Engineering Review

**FALCON FIELD
PRELIMINARY DRAINAGE REPORT
EL PASO COUNTY, COLORADO**

January 2021

Please add PCD File No.
SP21-001

SHEET TITLE EXISTING DRAINAGE MAP

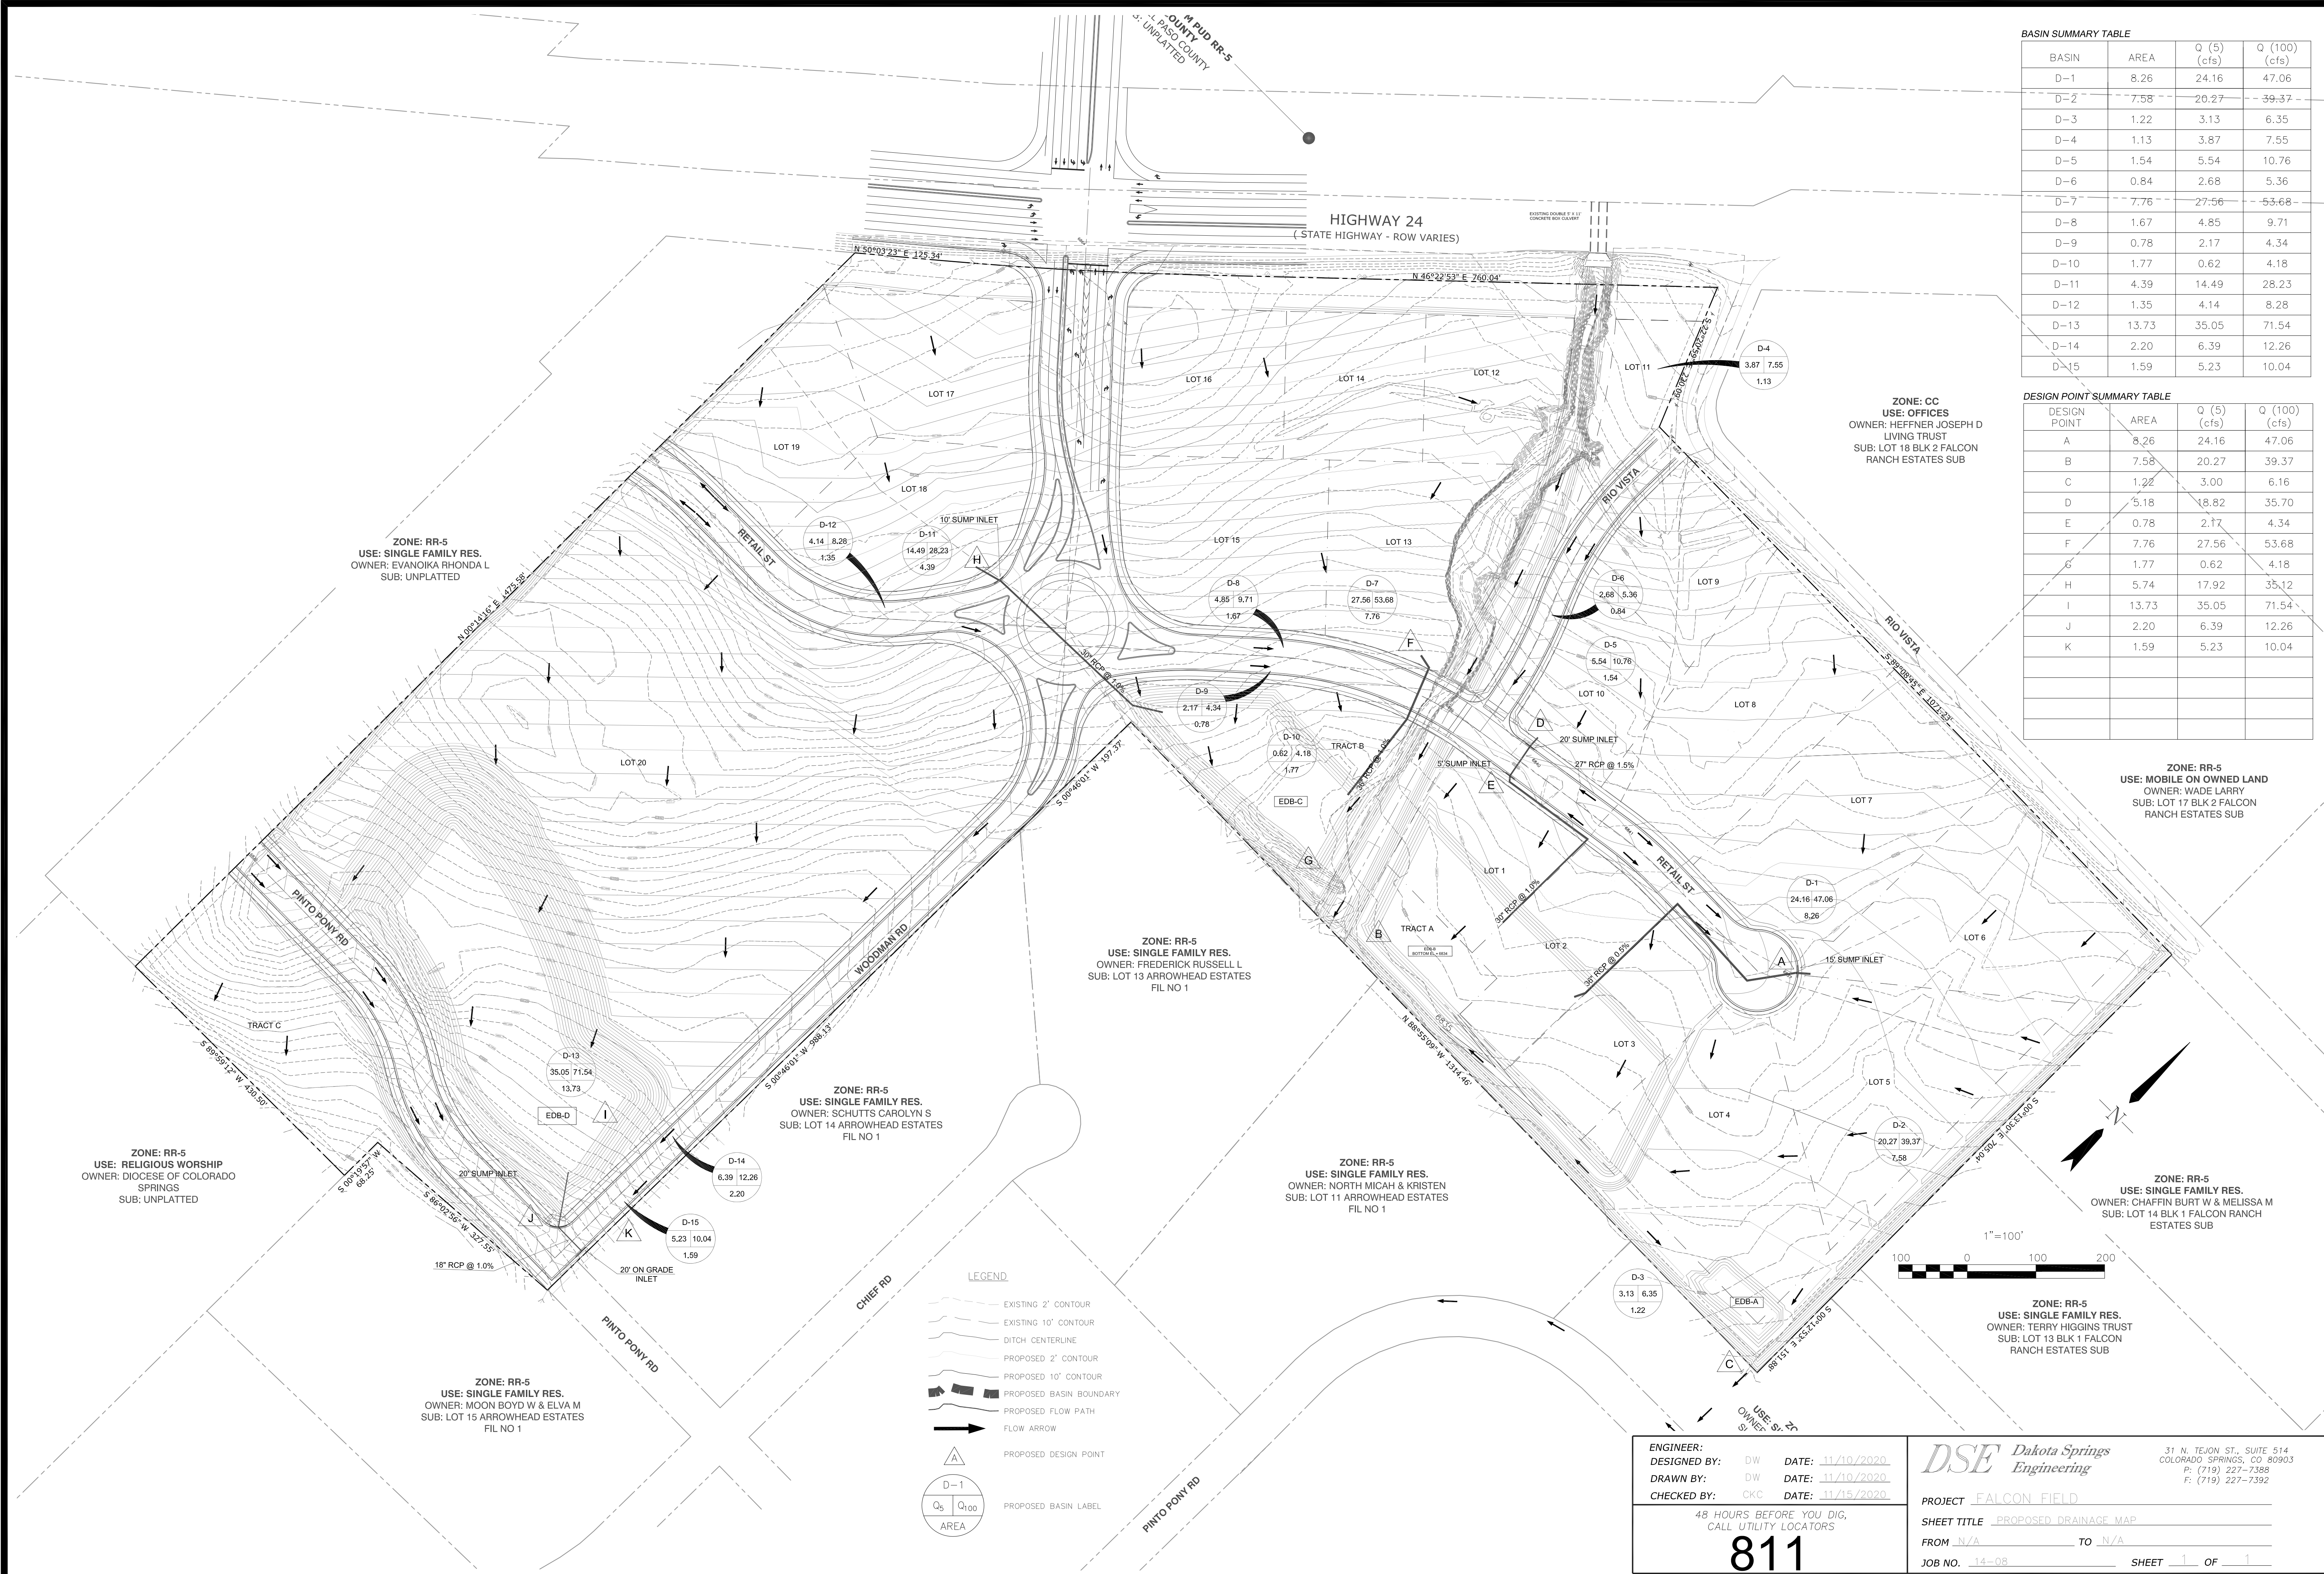
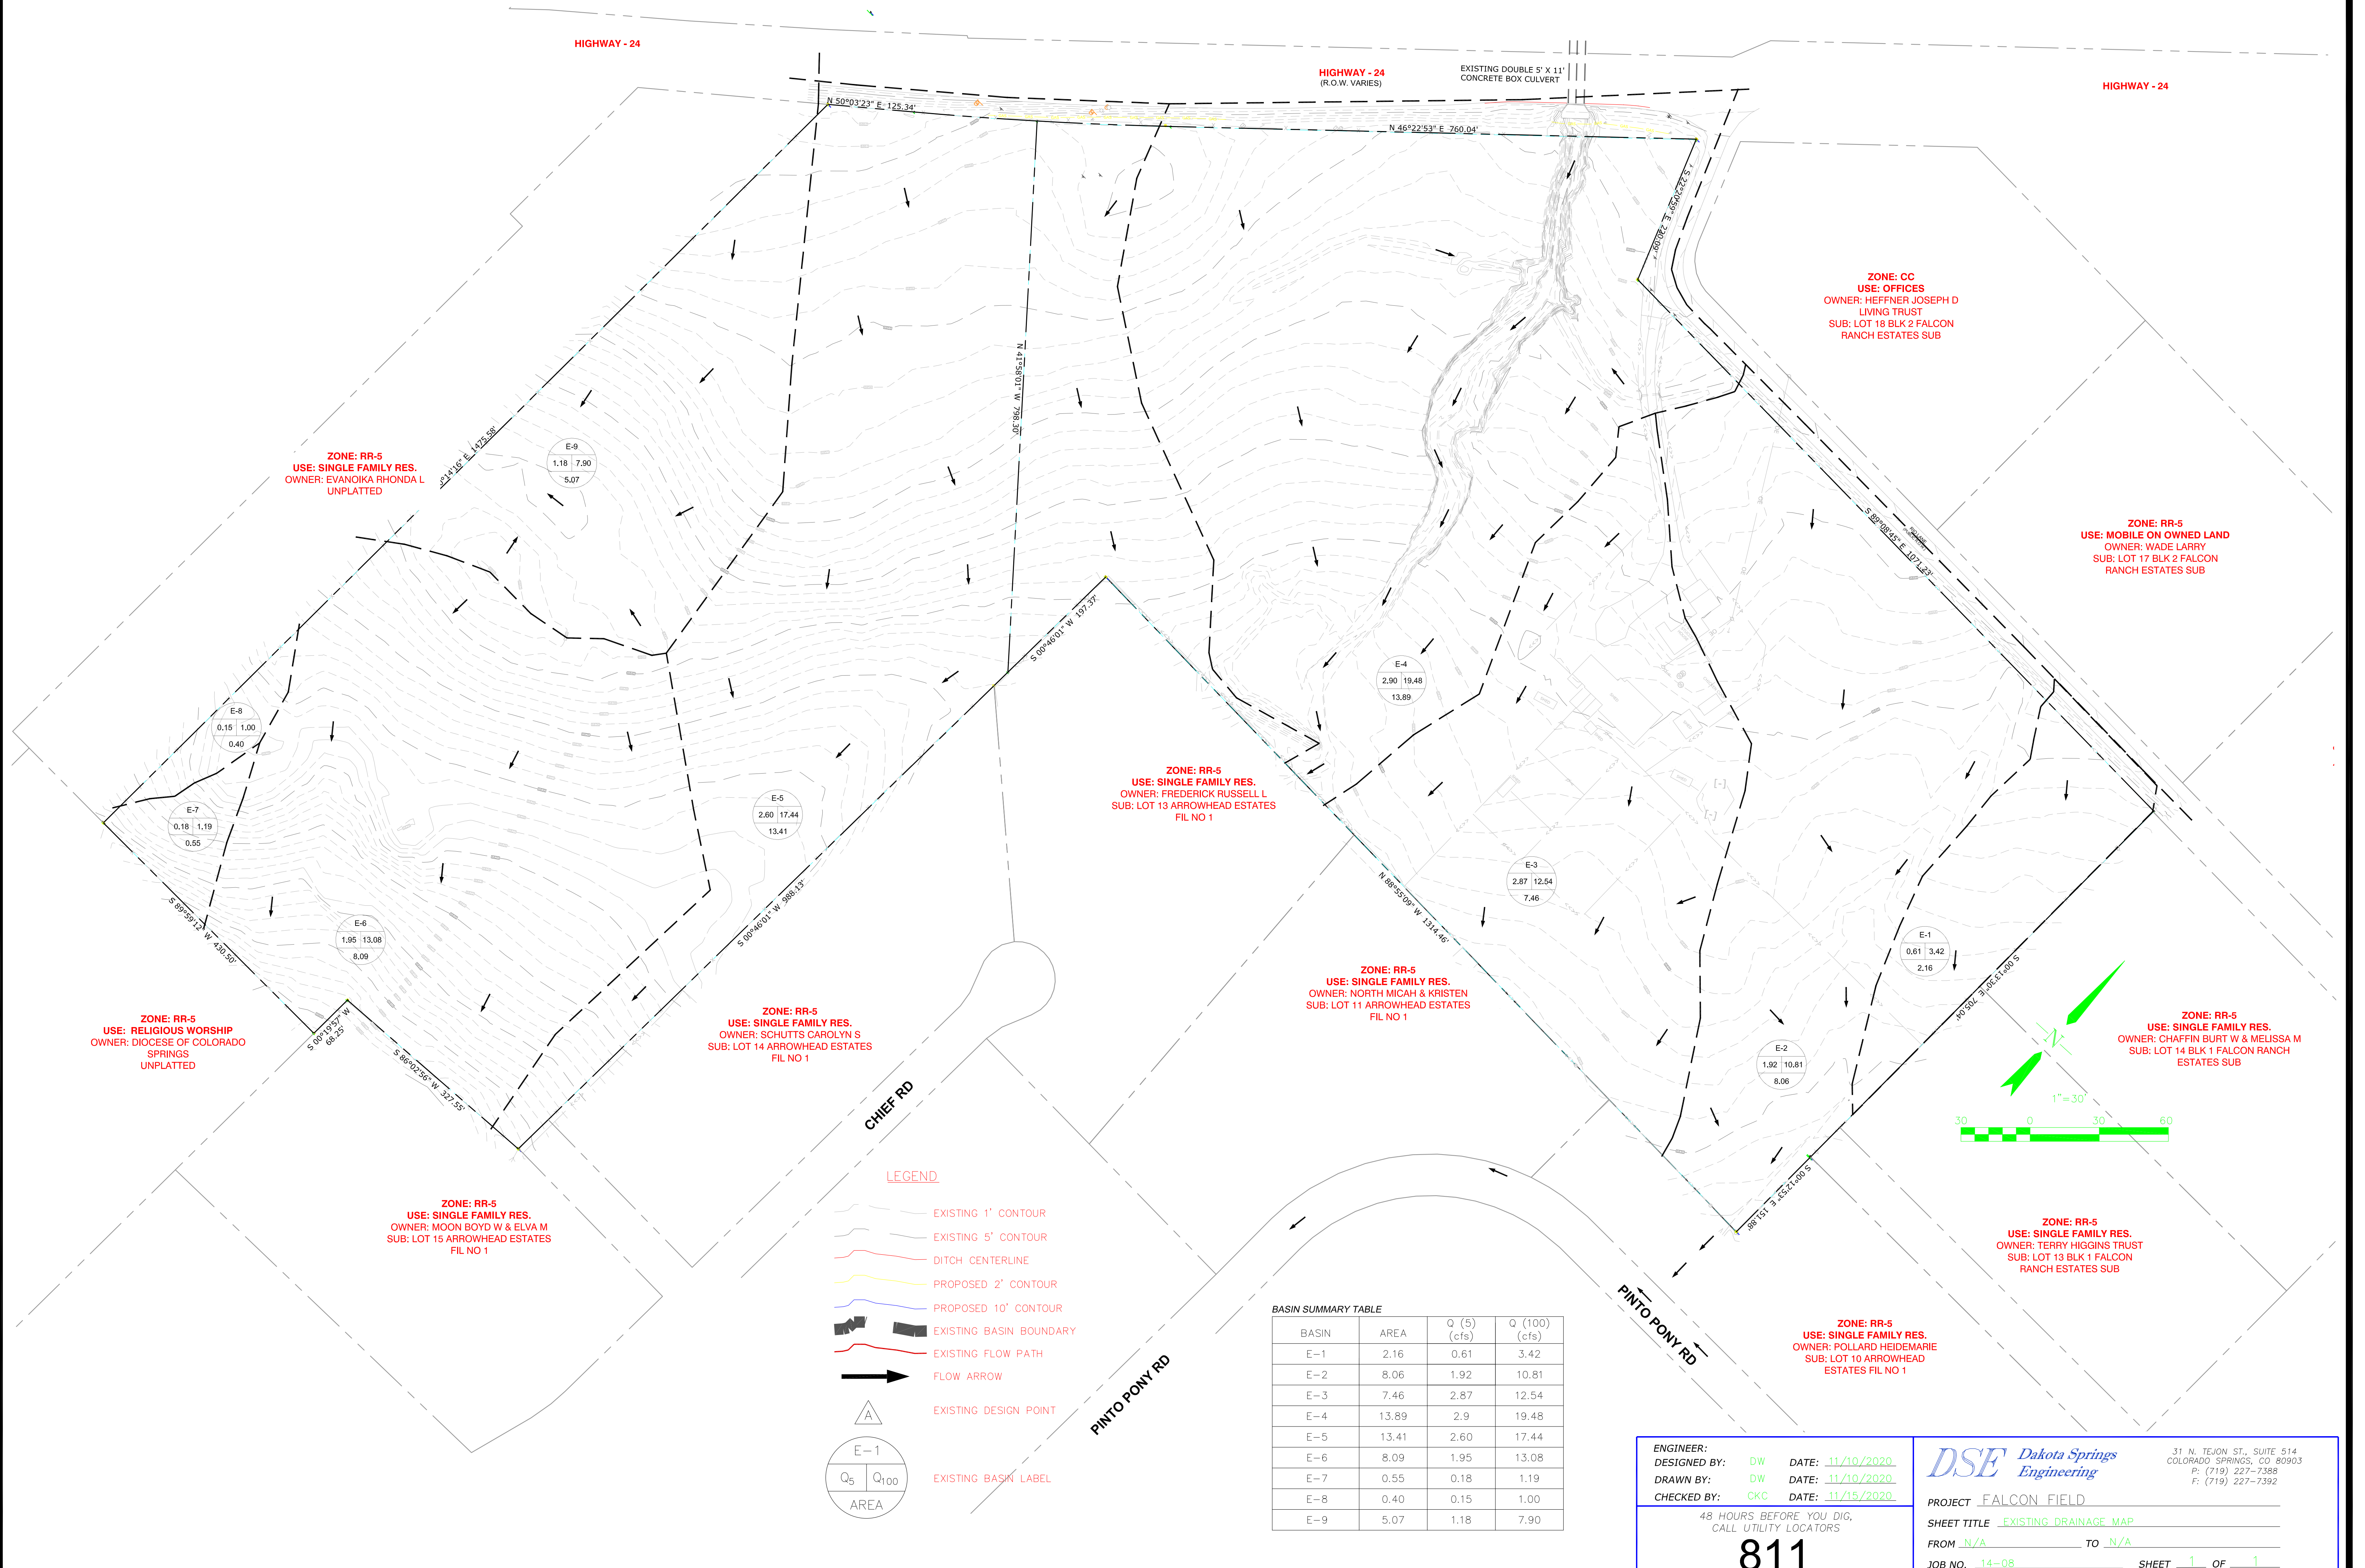
There appears to be runoff from the property to the north that enters this basin. Please be sure to account for it in your design. See comment in the existing drainage plan

Not all runoff from the site is sheet flow. Regardless of sheet flow or concentrated flow, design points should be provided in the appropriate locations indicating the "Q" for the minor and major storm events. Please provide the appropriate design points in your report and drainage plan.
